Response to Planning Application

Application ref: BR/67/22/DOC

Description: Approval of details reserved by condition imposed under BR/281/18/PL relating to conditions 3-site meeting with ADC tree officer & Arboricultural Expert, 7-landscape details & 9-details of new screen walls and/or fences

Location: 99 Victoria Drive Bognor Regis PO21 2DZ

PROPOSED SITE/LANDSCAPE PLAN

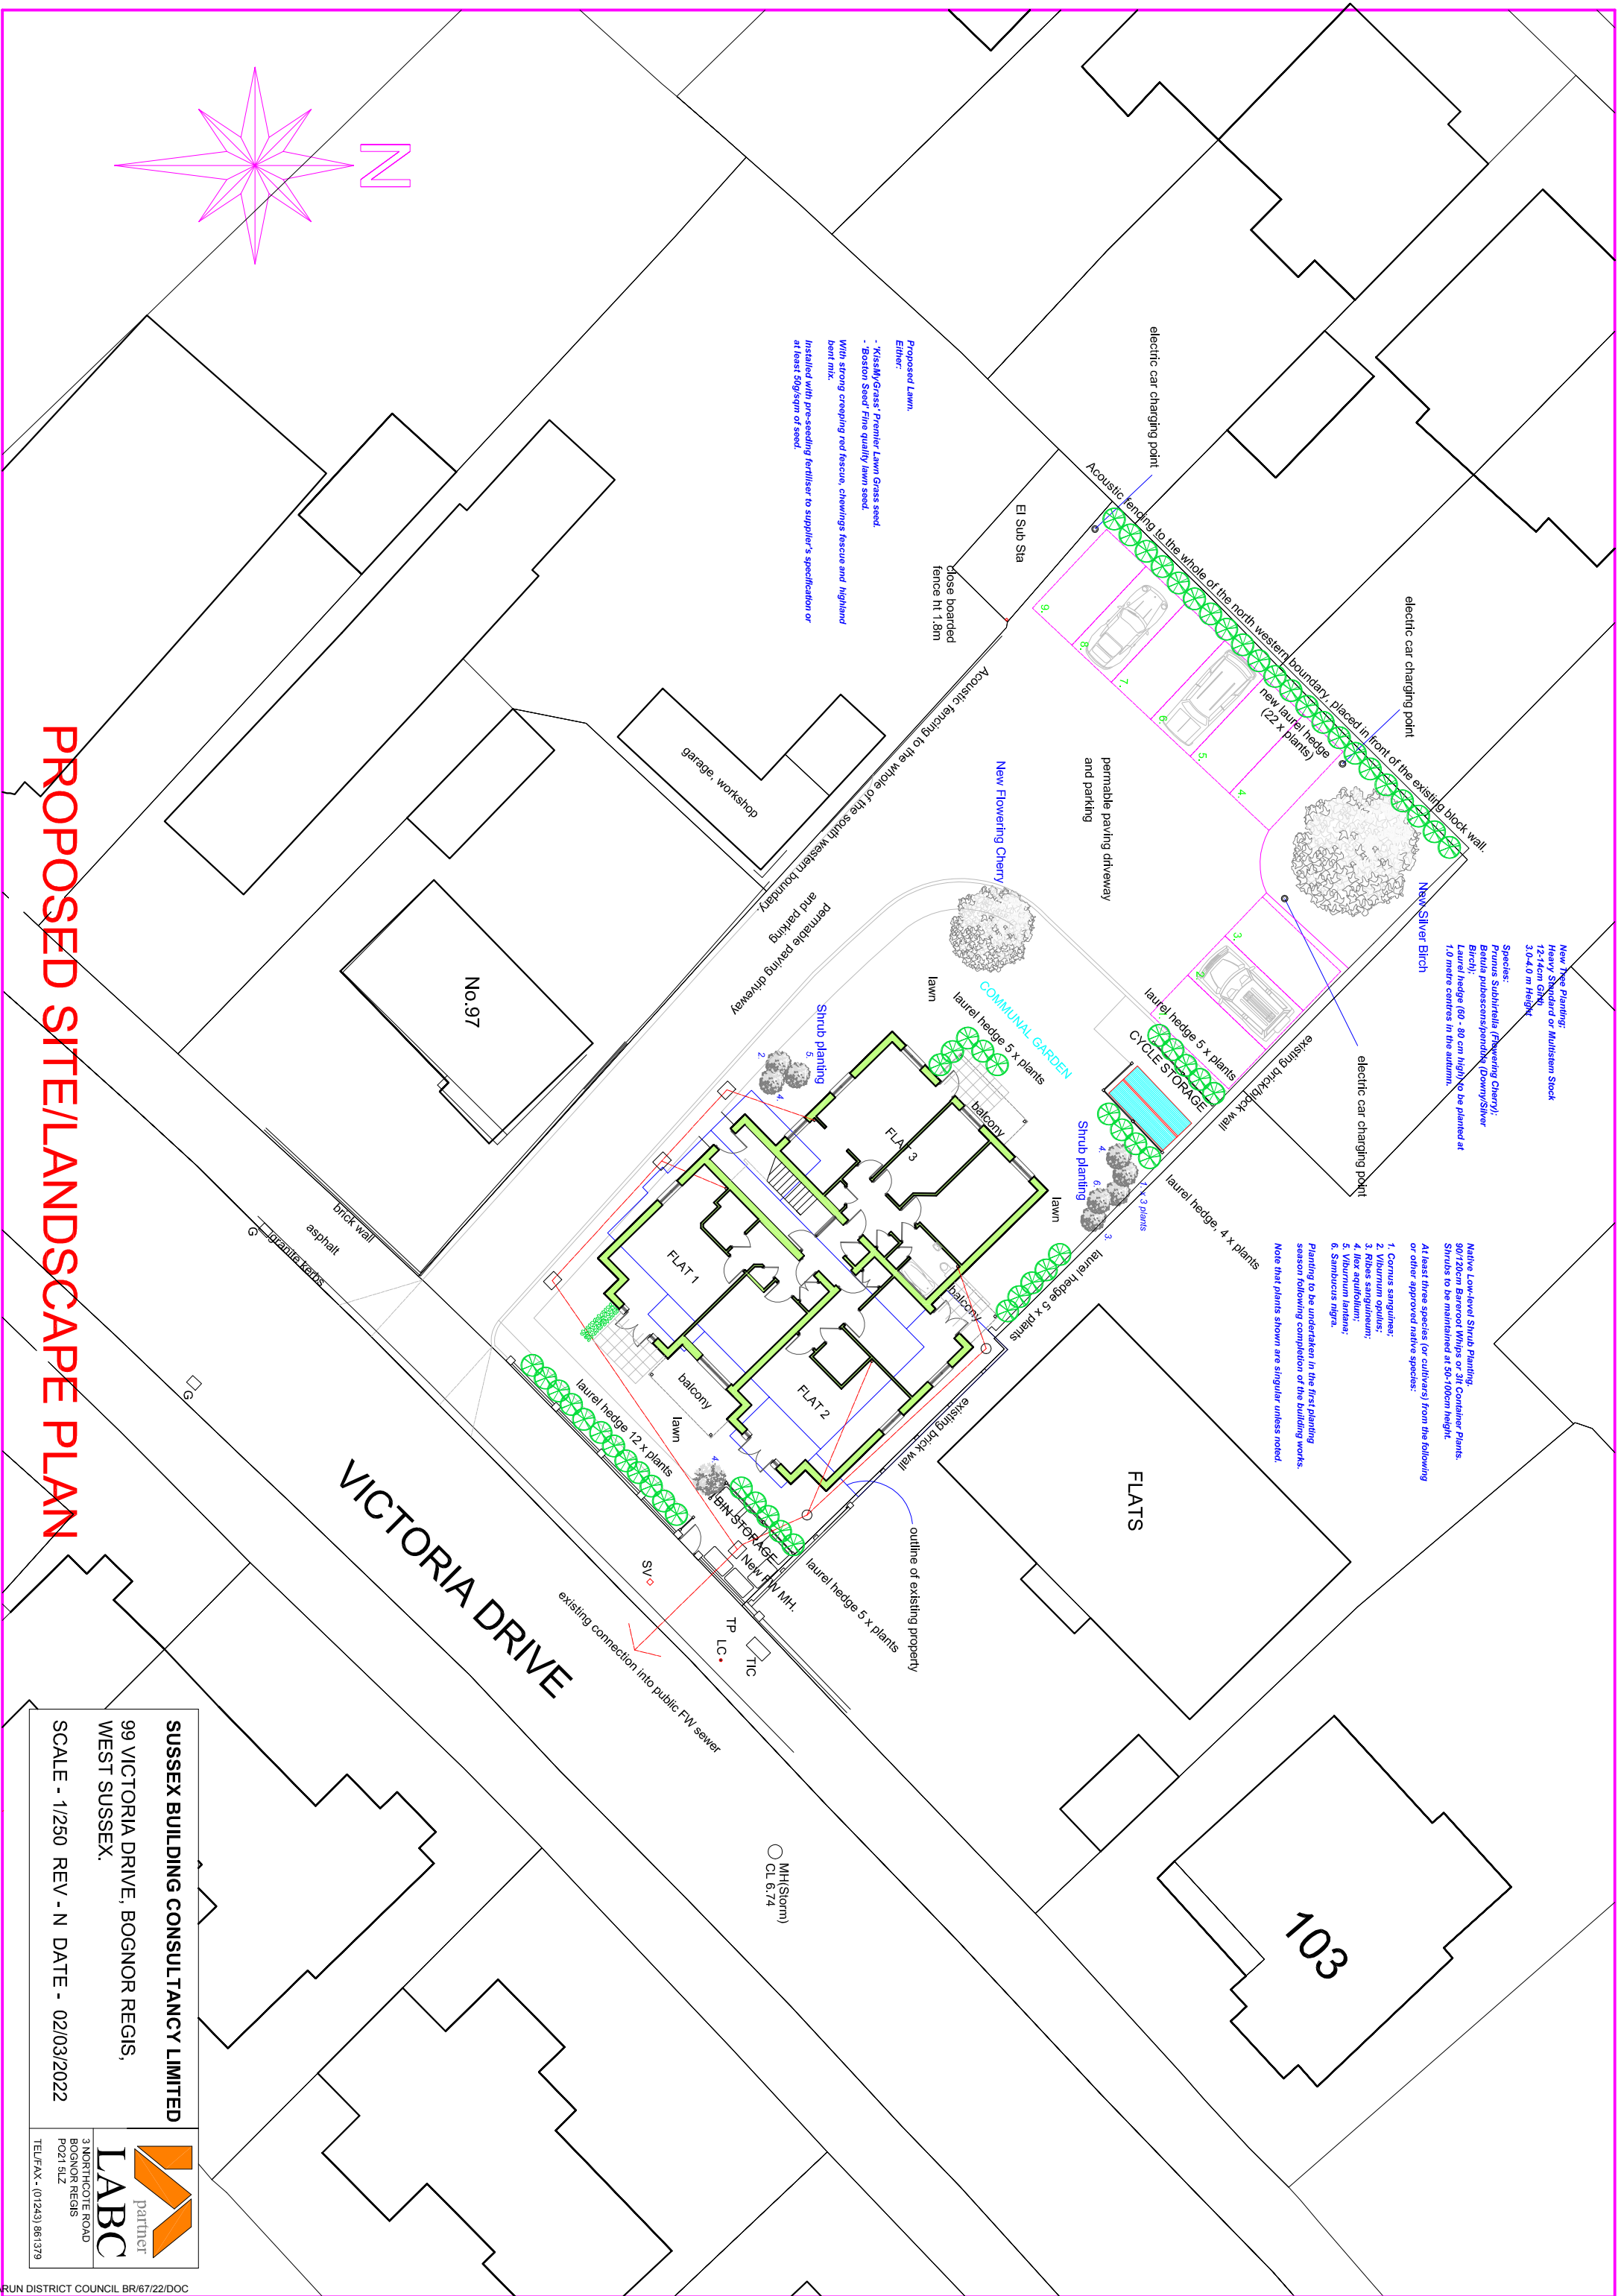
The detail submitted under the Proposed Landscape Plan Rev N details a landscape scheme which would be fitting for location and has detailed the proposed planting scheme in plan form with species choice, planting densities and size at time of planting. The proposals over time would provide suitable green infrastructure to these proposals.

Recommend the discharge of Condition 7 - landscape details imposed under BR/281/18/PL on this application BR/67/22/DOC
